Prior Notification for Permitted Development

Development: Prior notification under Schedule 2, Part 3, Class Q for the change of use of the main barn and the dairy to provide 3 units of tourist accommodation.

Location: Morrells Farm Lower Bognor Road Lagness PO20 1LR

Proposed Ground Floor Plan
Barn 1

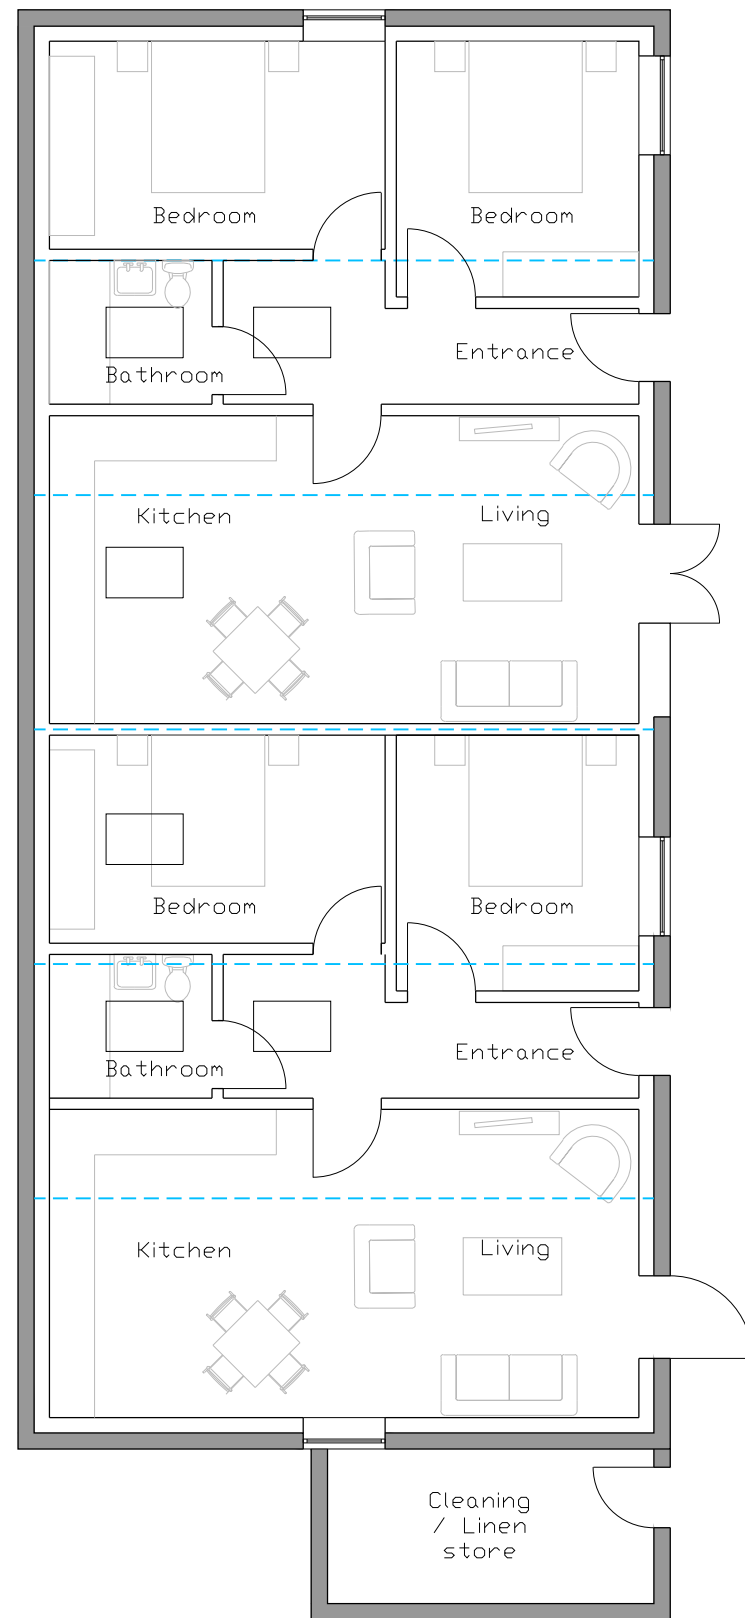
For Barn 1 please provide the floor area of each room and provide the measurements of all windows and doors.
